CITY OF ALBUQUERQUE

**RE: Love's – Broadway / Sunport
3200 Broadway Blvd SE
Interim Grading and Drainage Plan for Demolition
Engineer's Stamp Date: 04/17/24
Hydrology File: M14D038**

Based upon the information provided in your submittal received 04/17/2024, the Interim Grading and Drainage Plan for Demolition is not approved for Grading Permit and Demolition Permit. The following comments need to be addressed for approval of the above referenced project:

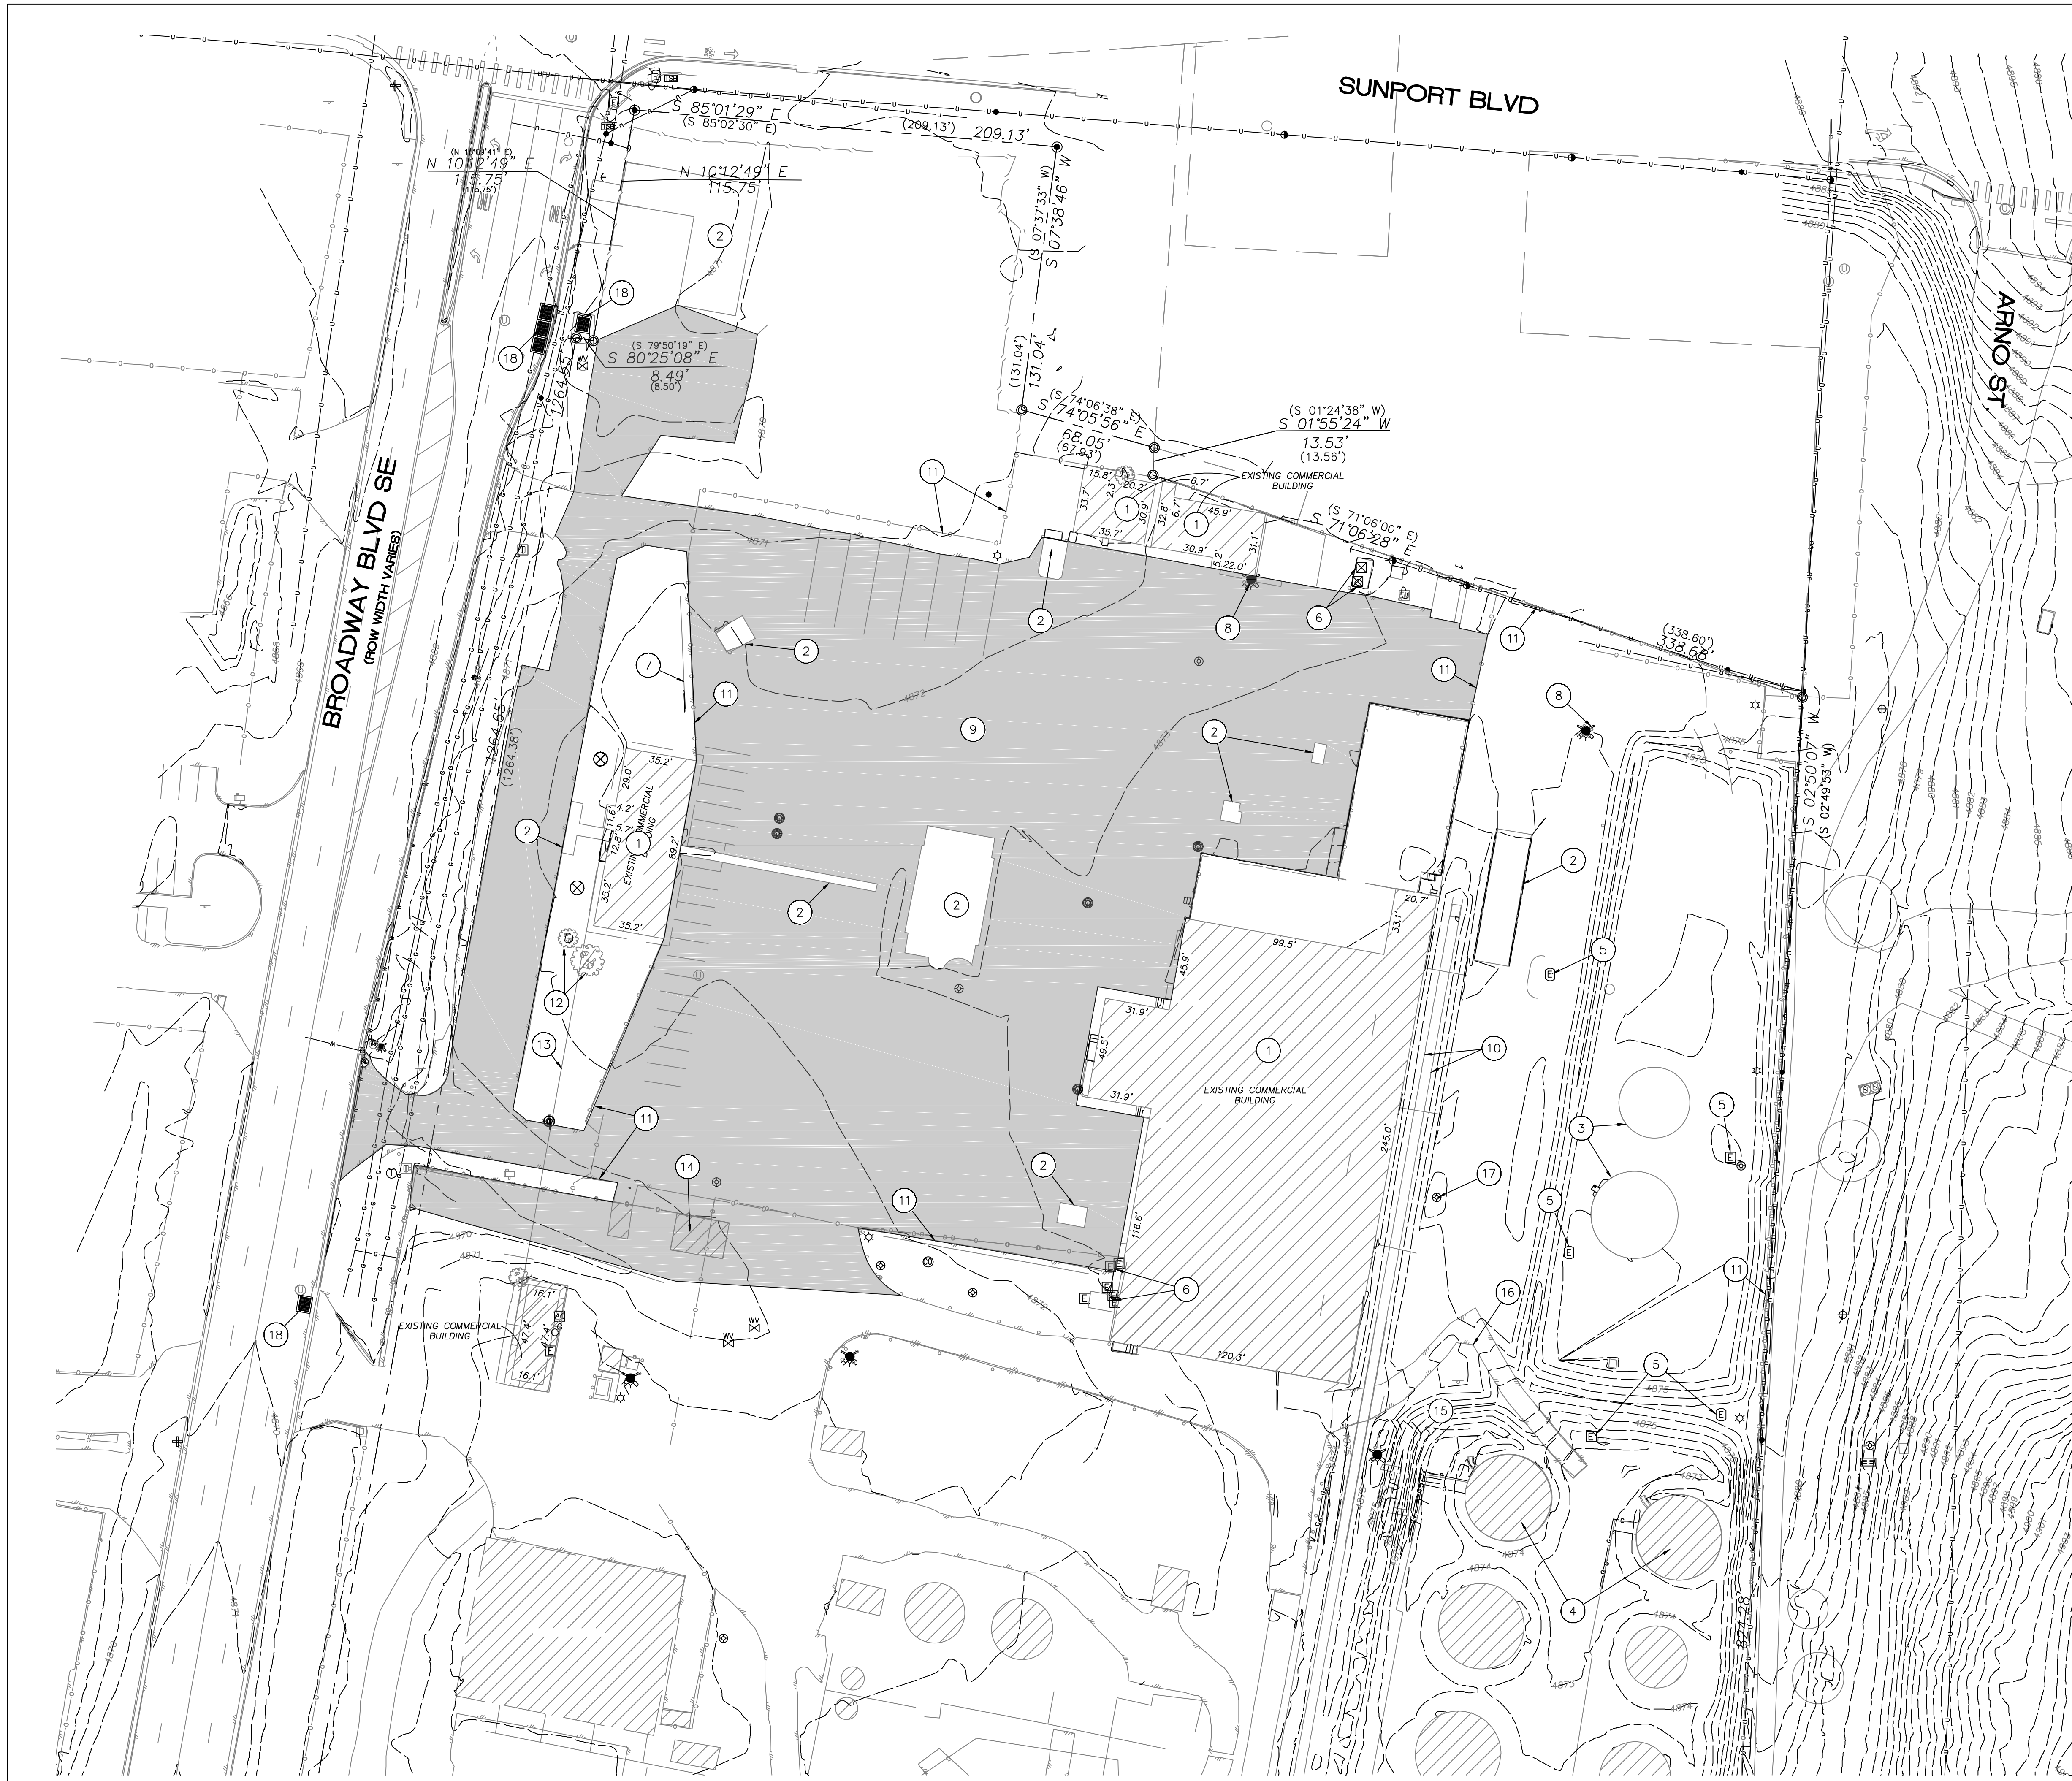
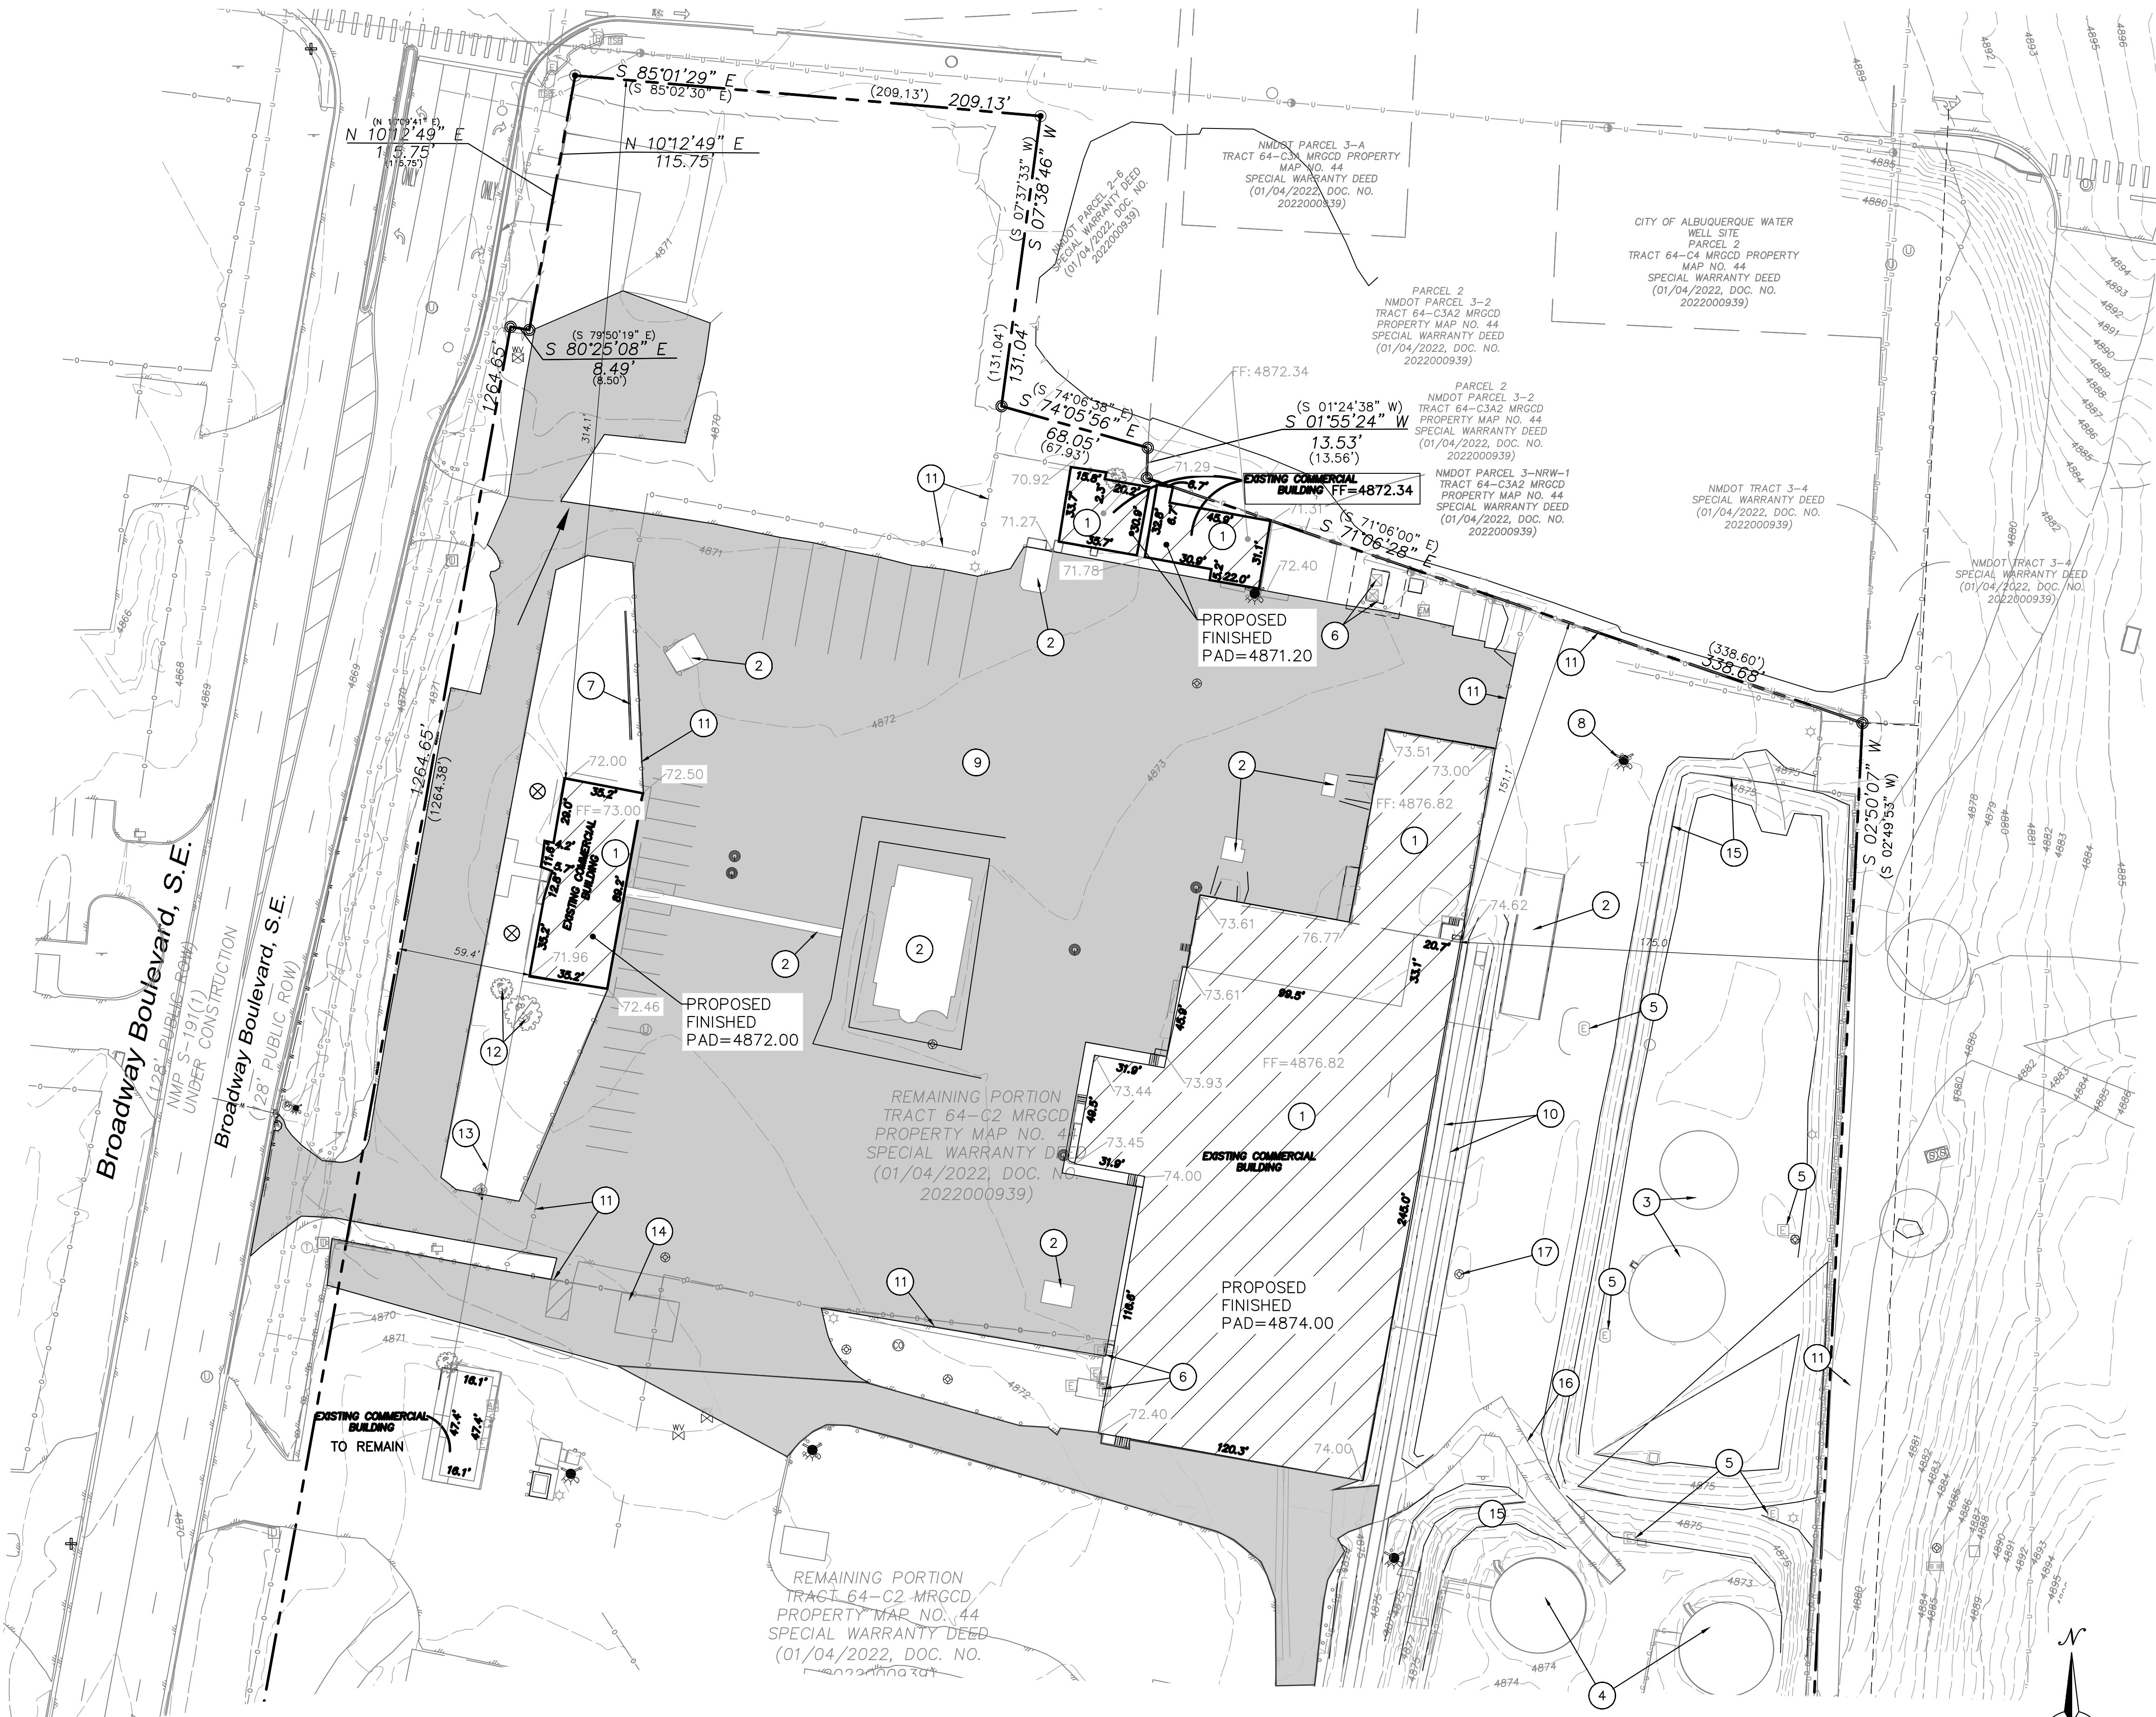
1. Please provide a retention pond for this site. Drainage from this site cannot leave the site during this interim stage of construction.

2. Please note that this site currently drains to an inlet at the northwest corner of property. Please protect this inlet from drainage escaping from site. Please show the two existing inlets on Broadway.
